From: Amanda Scholes on behalf of Planning.Responses
Sent: 12 June 2020 08:52
To: Planning Scanning
Subject: FW: Planning Consultation on: P/24/20/RES

Response to Planning Application

Application ref: P/24/20/RES

Location: Land North of Sefter Road & 80 Rose Green Road Pagham

FIGURE 5.9: PLAY AREA PLAN AND VISUALS

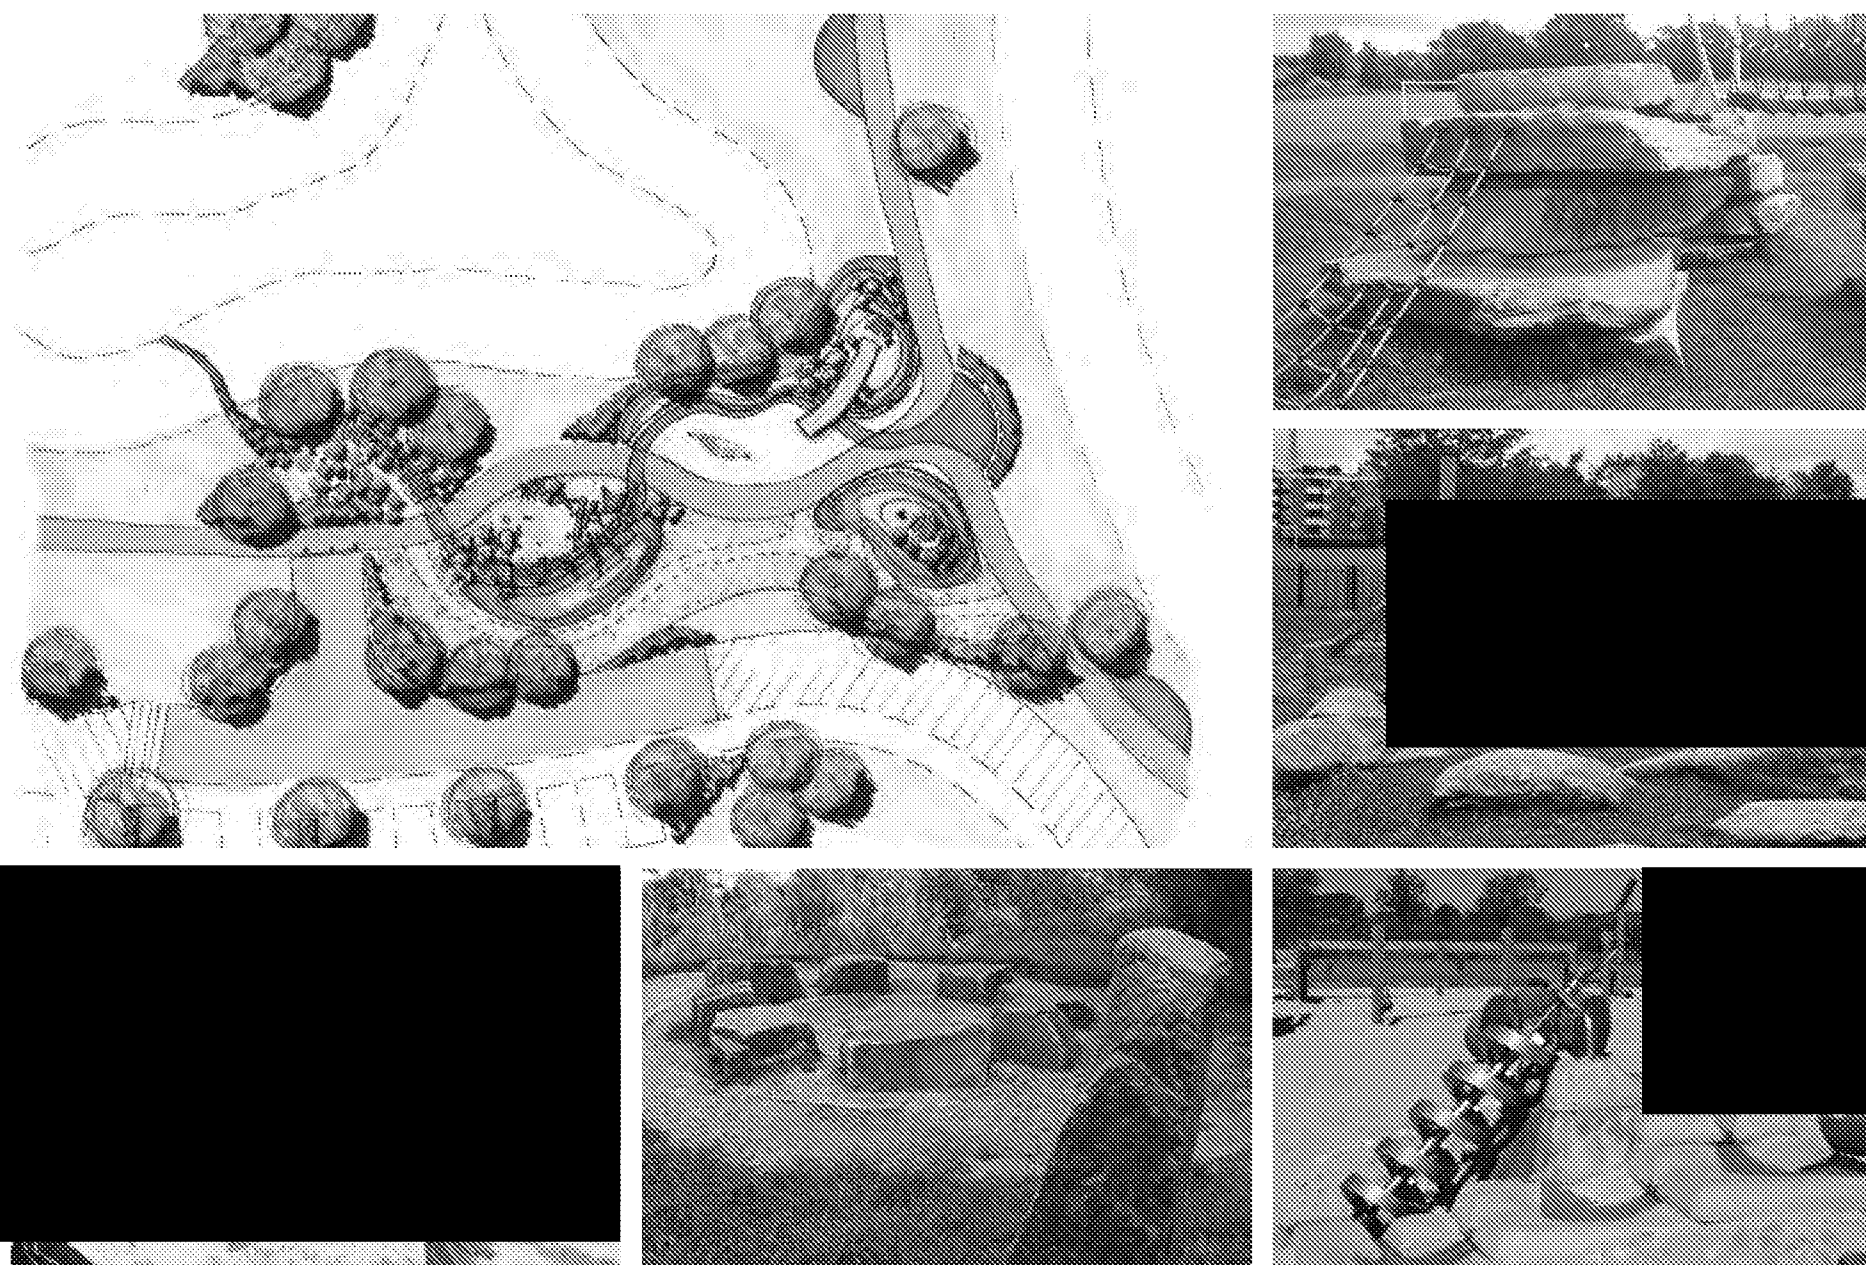
The character area plan shows only 1no LEAP and 1no LAP for the site. Previous consultation and 106 agreement had concluded in a requirement for an enhanced LEAP catering for a minimum 8 play experiences and for there to be several LAPs located within the site. There doesn't appear to be any detail re the proposals for these and the play provision offered. We would need to see the equipment choice, surfacing, fencing and connectivity to the pathway network for the formal play and the design thought for the more informal natural based play space. LAPS to be unequipped open space areas catering for the very young with a combination of natural play features in landform, logs, boulders, seats and bins. It would be required that additional LAPs are located within this development.

Dwg no JSL3457-RPS-XX-EXOR-L-904 dwg 4 of 9 indicates the pathway running through the LEAP play area. It is not encouraged to have a primary connecting route bisecting a play area. Whilst paths need to connect to these, primary pathway/cycleway should not be through the play area.
